**WELWYN HATFIELD BOROUGH COUNCIL
EXECUTIVE DIRECTOR - PLANNING, PUBLIC PROTECTION AND GOVERNANCE**

DELEGATED APPLICATION

Application No: 6/2021/2791/HOUSE
Location: 28 Theobalds Road Cuffley Potters Bar EN6 4HQ
Proposal: Conversion of loft to habitable space including roof alterations, the addition of side dormers and the erection of a part first floor and part single storey side and rear extension
Officer: Ms Emily Stainer

Recommendation: Granted

DPL 03
www.discountplanning.com

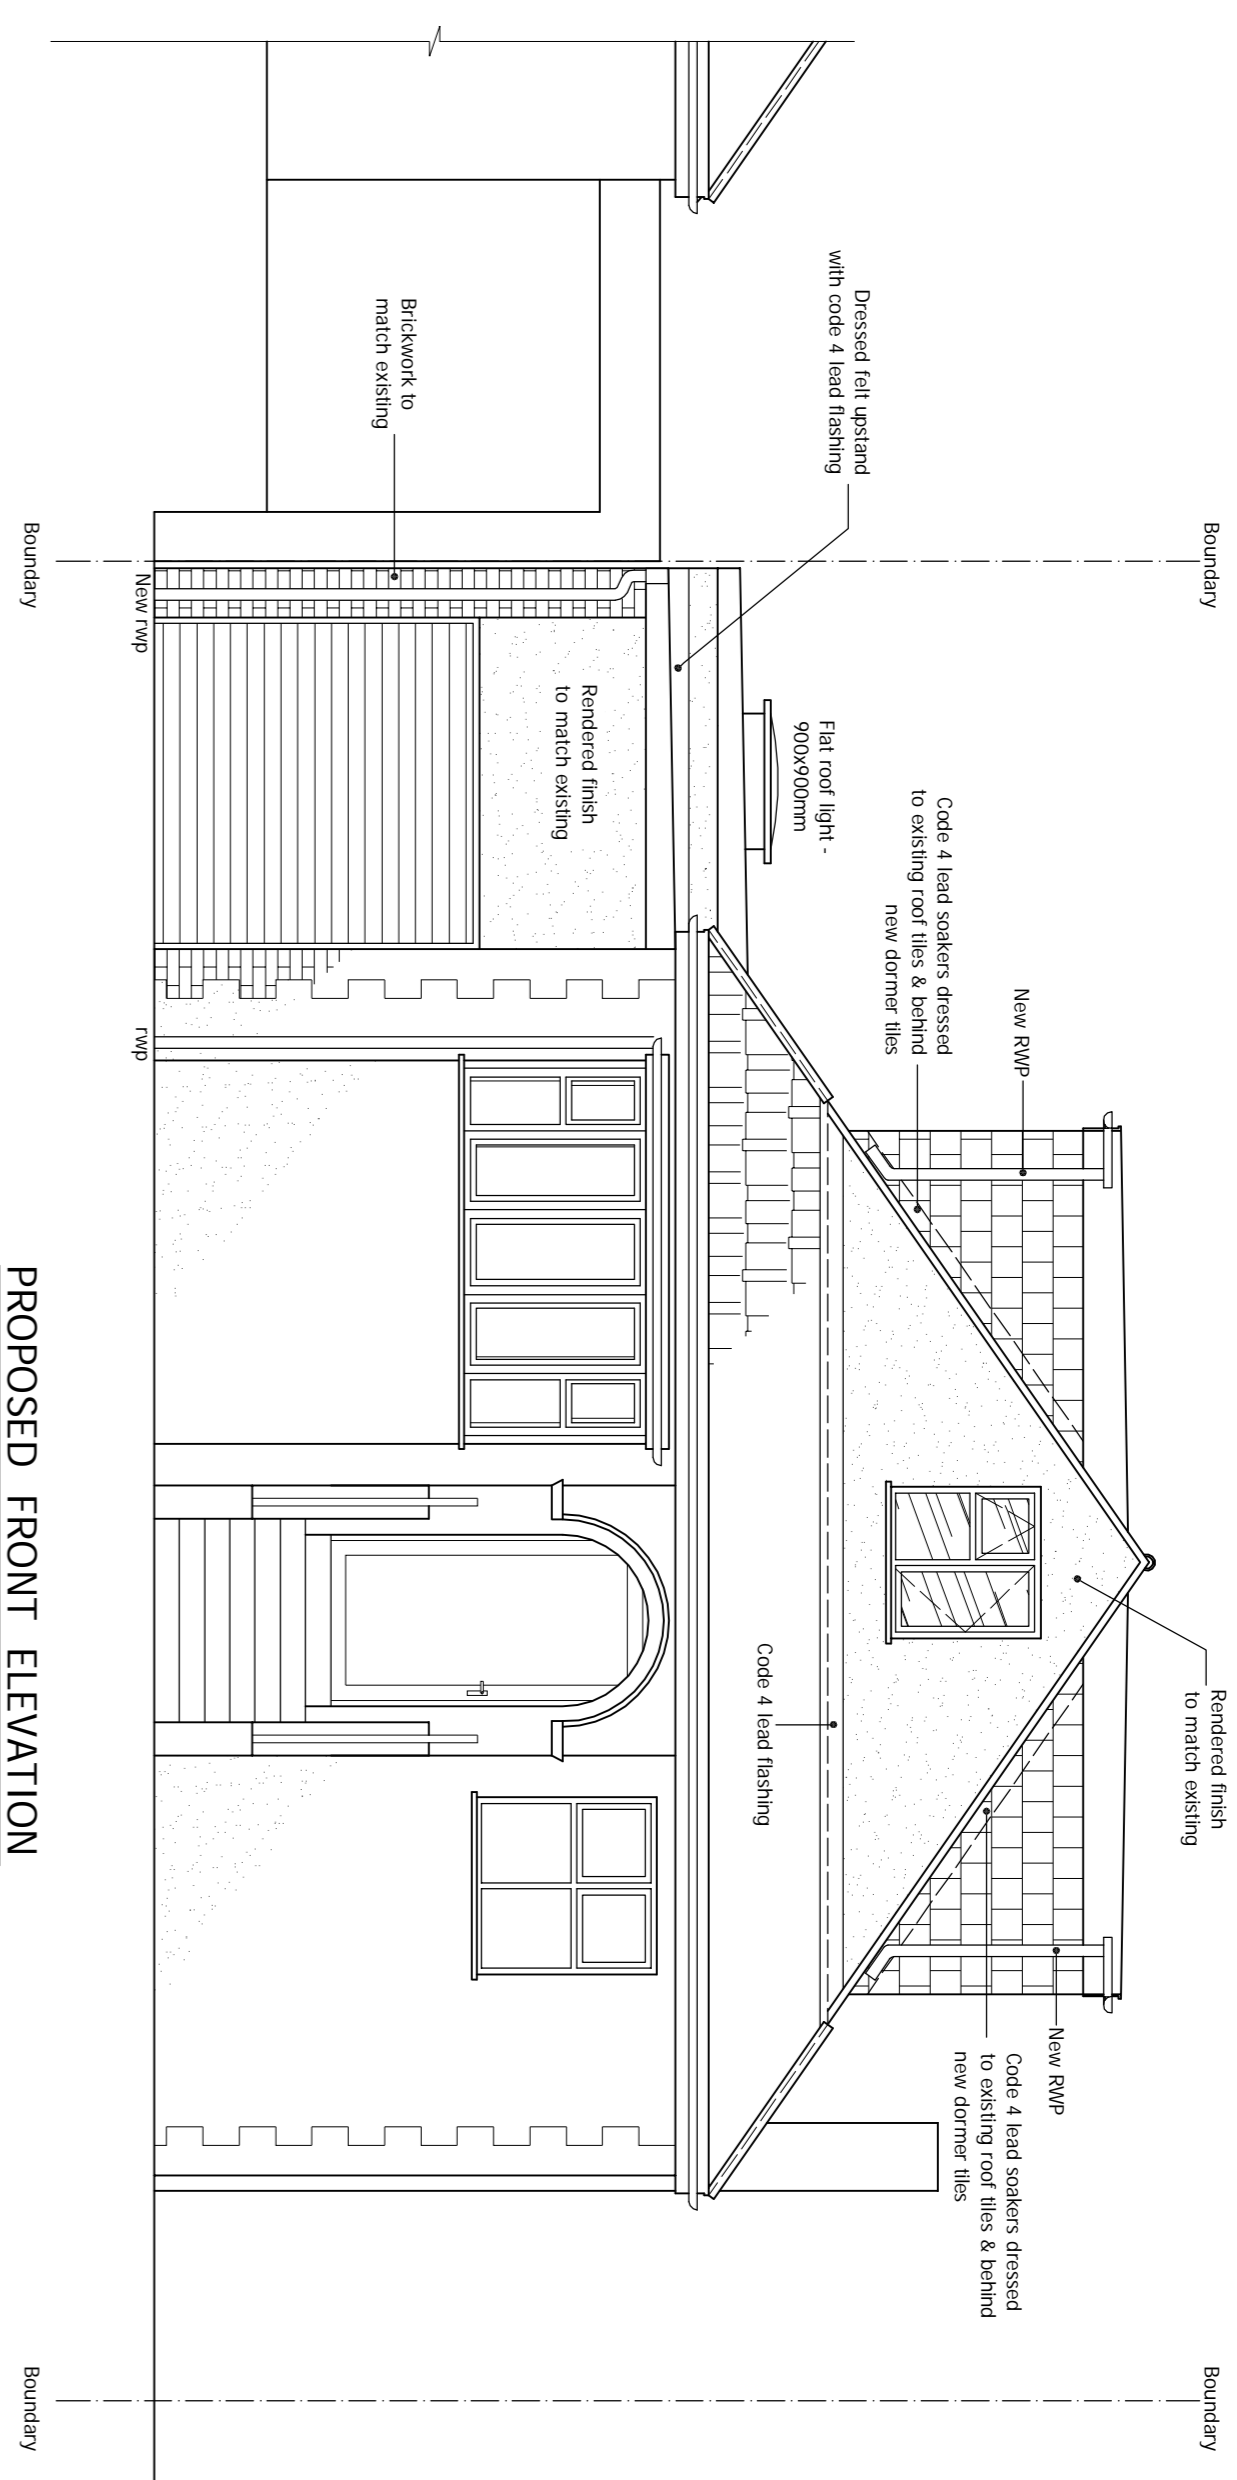
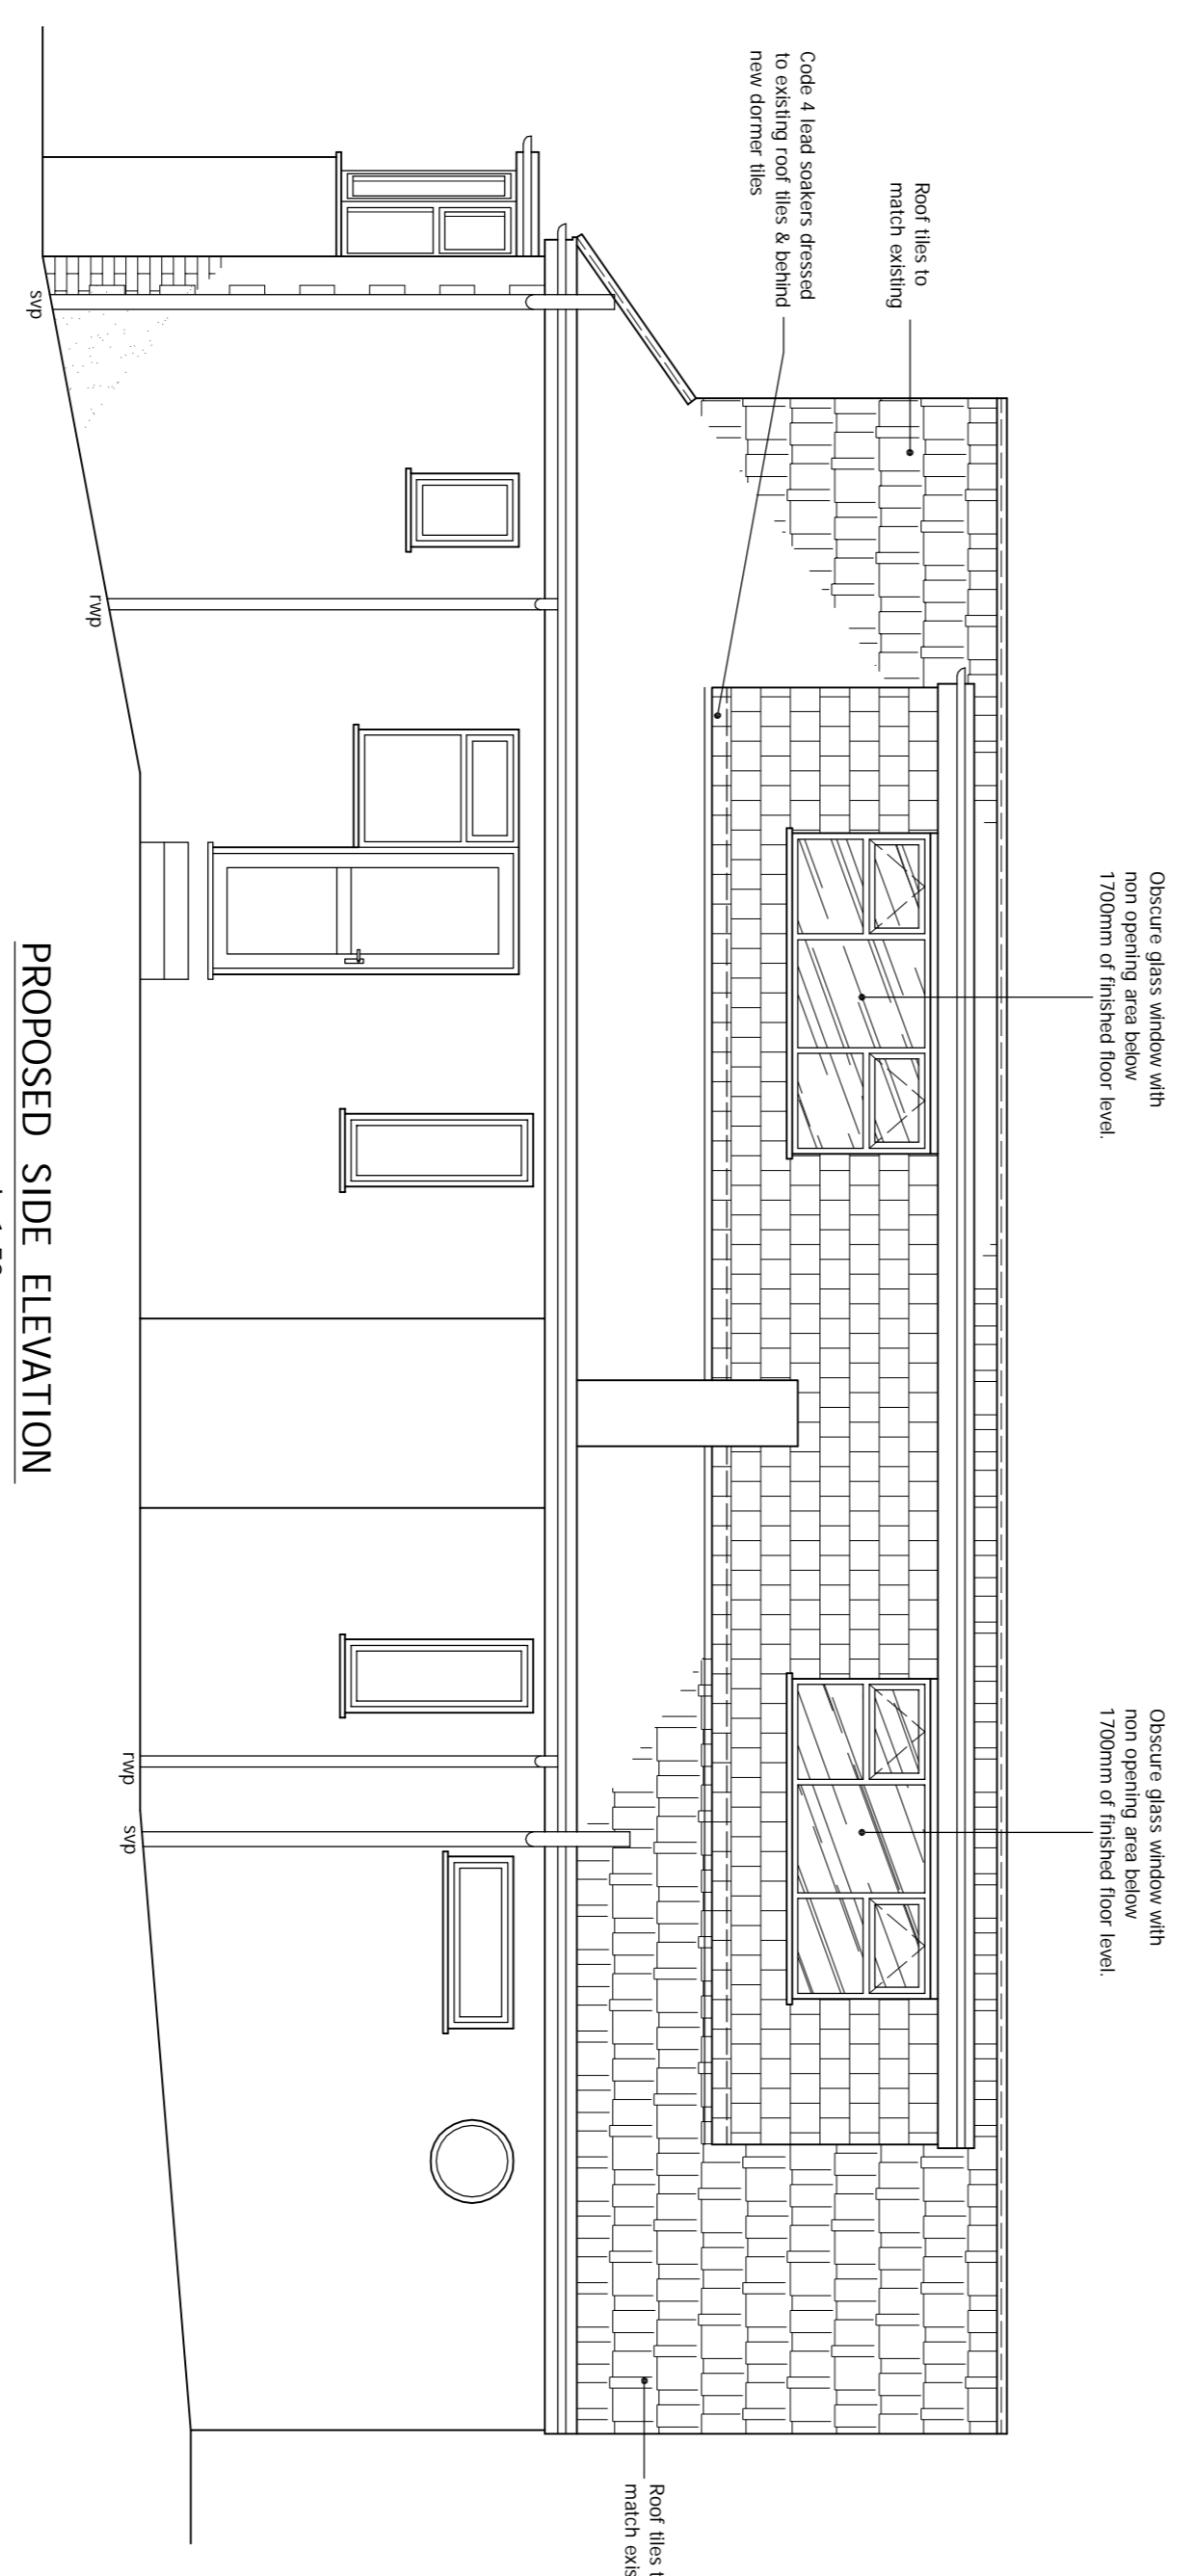
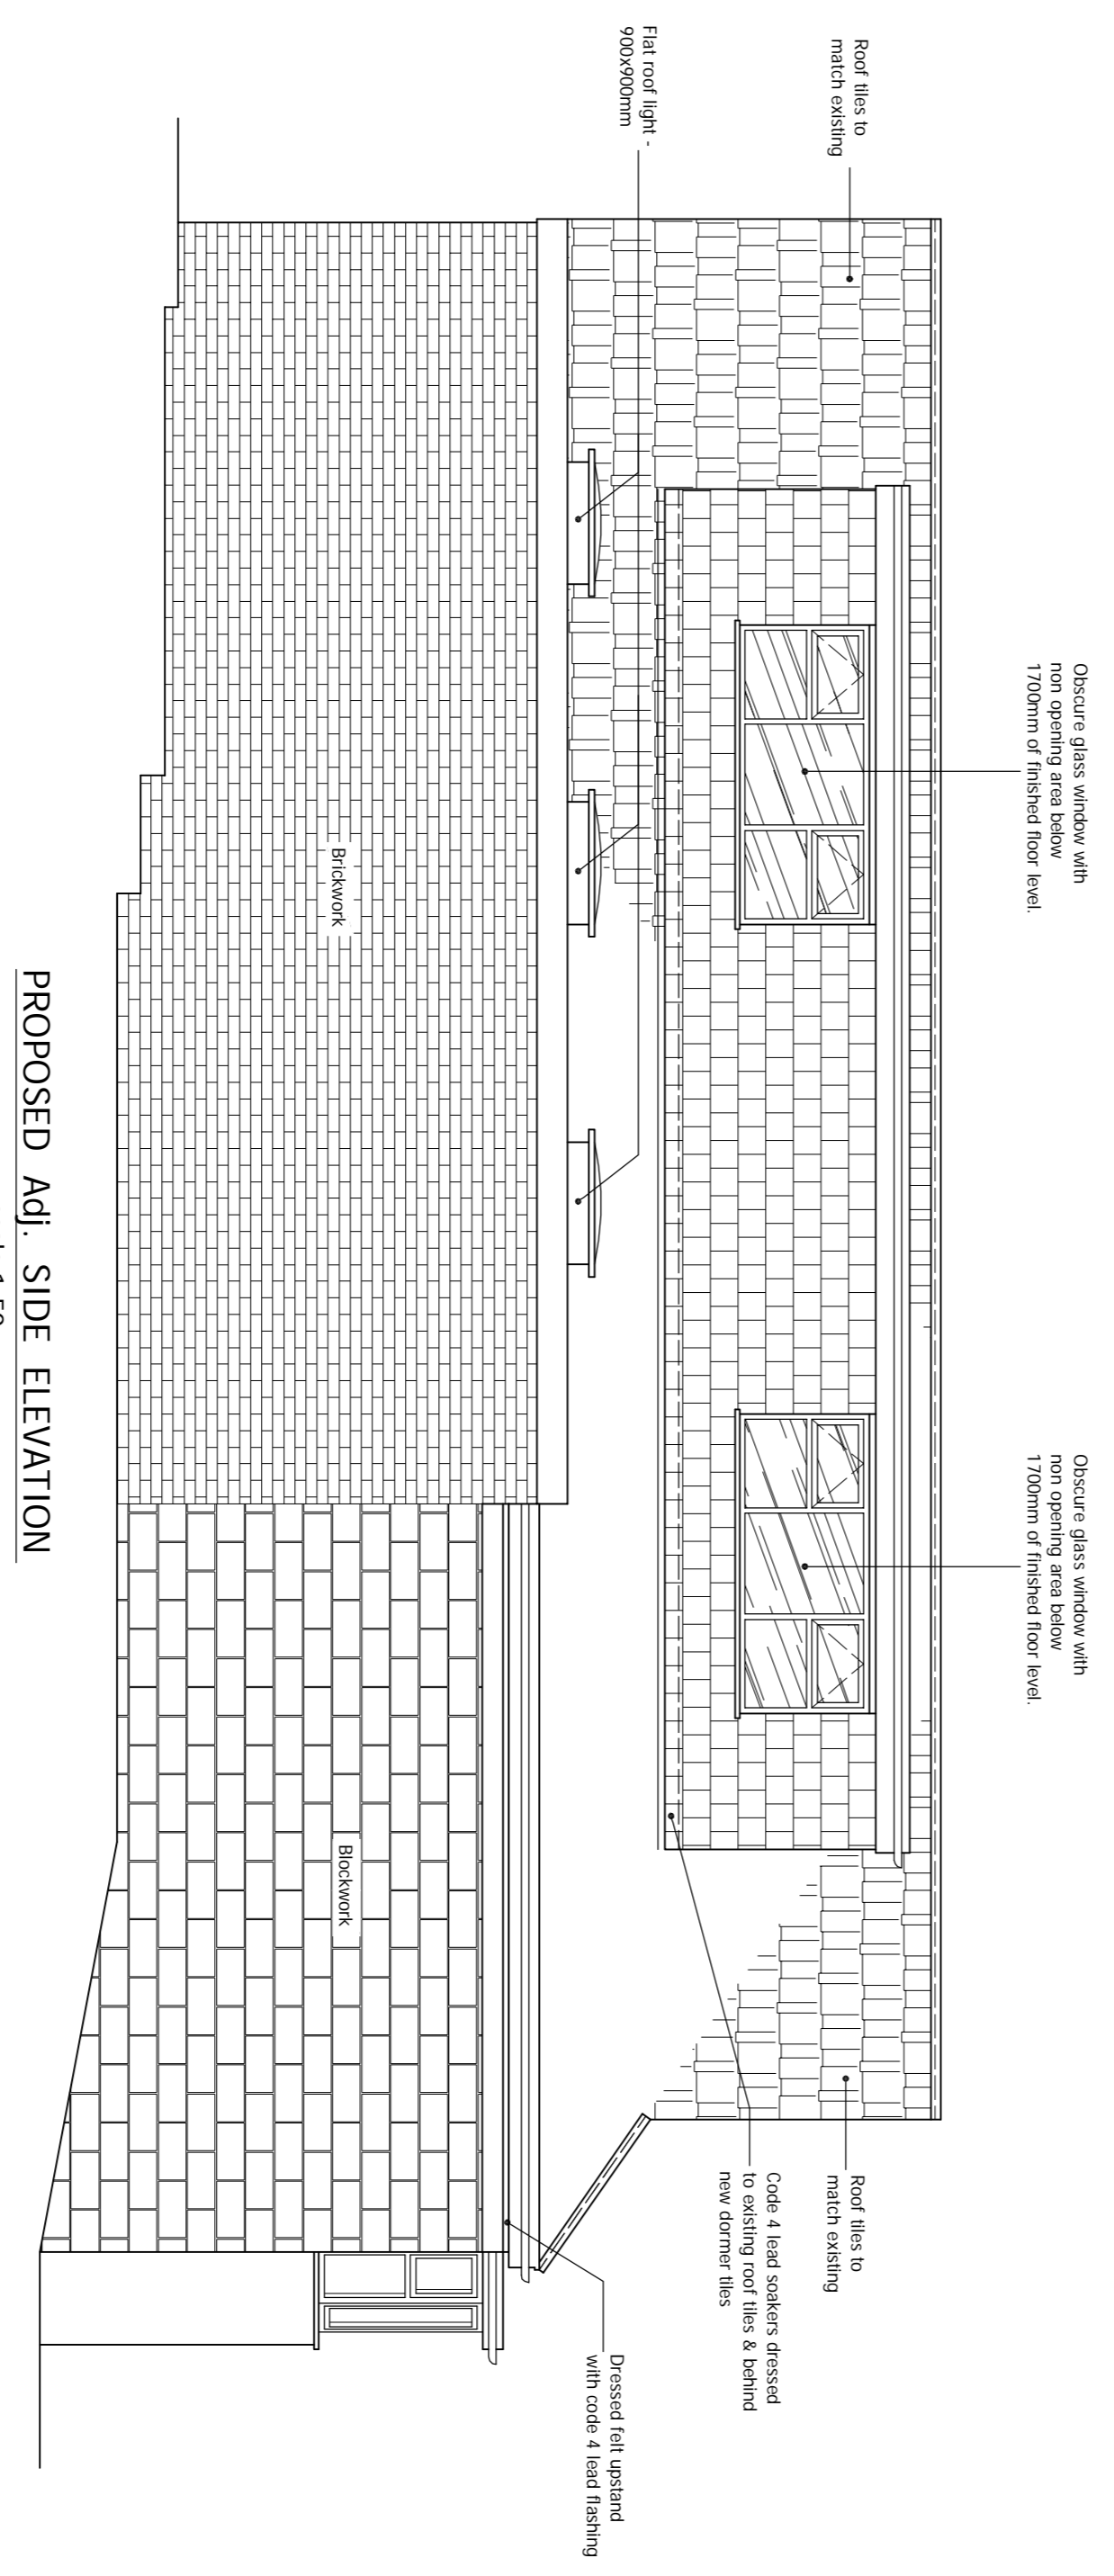
dormers were proposed on each side of the building, each with two windows. The combined width of the initial dormers on each side would have been approximately 11.8m (5.9m in width) and a height of approximately 1.8m. The amended design includes a single dormer on each side which would measure approximately 10m in width and would be set in from the front and rear of the roofslope by at least 1m. Each dormer would only benefit from two windows and they have been reduced in size from the previous proposal in order to integrate better with the fenestration pattern on the existing house. The amended design is considered to be more appropriate to the existing dwelling and to the context in the surrounding street scene. The plans state that roof tiles, brickwork and render will match existing but there are limited details in respect of window/door materials. Therefore, a condition will be imposed which ensures the materials match existing.

The neighbours either side of the application property (26 and 30 Theobalds Road) both submitted comments on the original proposal. Both properties have previously been extended in the past. The comments submitted refer to a loss of privacy and light from the proposed dormers and the design of the original dormers, including that there should be a reduction in the length of dormer windows at the rear of the property and the distance from the rear wall to the dormer should be a minimum of 1350mm. As the amendments to the design include a reduction in the overall size of the dormers and less windows are proposed than before, it has not been necessary to re-consult neighbours. However, it is worth noting that the single dormer on each side of the property now maintains a distance of approximately 1.9-2m from the front and rear of the property and the side windows are labelled as being obscure glass with a non-opening area below 1.7m above the finished floor level. This overcomes some of the points raised in the comments.

The proposed rear extension would not extend as far back as the rear of the property at No.26 and would project by approximately 4.4m further than the rear wall of No.30. Whilst this would inevitably create additional built form which would be visible from No.30, this neighbouring dwelling is located to the south of the application site, therefore the impact on sunlight would be unlikely to be significantly detrimental. Furthermore, the main bulk would be set back from the boundary line as the single storey extension would be closest to the boundary, at a maximum height of approximately 3.4m. On the opposite side, the built form would also be visible but it would be viewed in the context of that neighbours existing rear extension of a similar style to that proposed. The eaves would not be any higher than existing and the roof would still be hipped away from the boundary, minimising the visual impact of the extension. In terms of the impact from the dormers on light, the comments submitted from No.26 about sunlight do not detail which bedrooms would be likely to be impacted by the proposed extension and where exactly they are located. The historic planning records for this property do not indicate the layout on the first floor. However, a site visit confirmed that there are rooflights in their roof which may be affected. The proposed dormers have been reduced in overall width and have less windows to the original design. The dormer on the side elevation closest to No.26 would retain a separation distance of approximately 2.7m from the common boundary and would not extend any higher than the existing ridgeline, therefore, the impact is likely to be similar to that created by the existing roof.

It is also acknowledged that additional windows in the rear roofslope have the potential to create more overlooking compared to existing, which is currently restricted to ground floor level. Some degree of overlooking is acceptable which would be consistent with a neighbouring relationship generally expected between properties in an established residential area. Additionally, it is noted that dormer windows and rooflights are allowed under permitted development rights, giving an indication

that at a national level they are not considered to not have an unduly detrimental impact on the amenity of neighbouring properties, particularly in respect of privacy. It is therefore viewed that the impact overall would be acceptable in this scenario, subject to a condition requiring the side windows to be obscure glazed and fixed as set out on the plans. This is acceptable as the bedroom in the roof space would have front and rear windows with an acceptable outlook.

2. Any upper floor window located in a wall or roof slope forming a side elevation of the building hereby approved must be obscure-glazed and non-opening unless the parts of the window which can be opened are more than 1.7 metres above the floor of the room in which the window is installed, and shall be retained in that form thereafter.
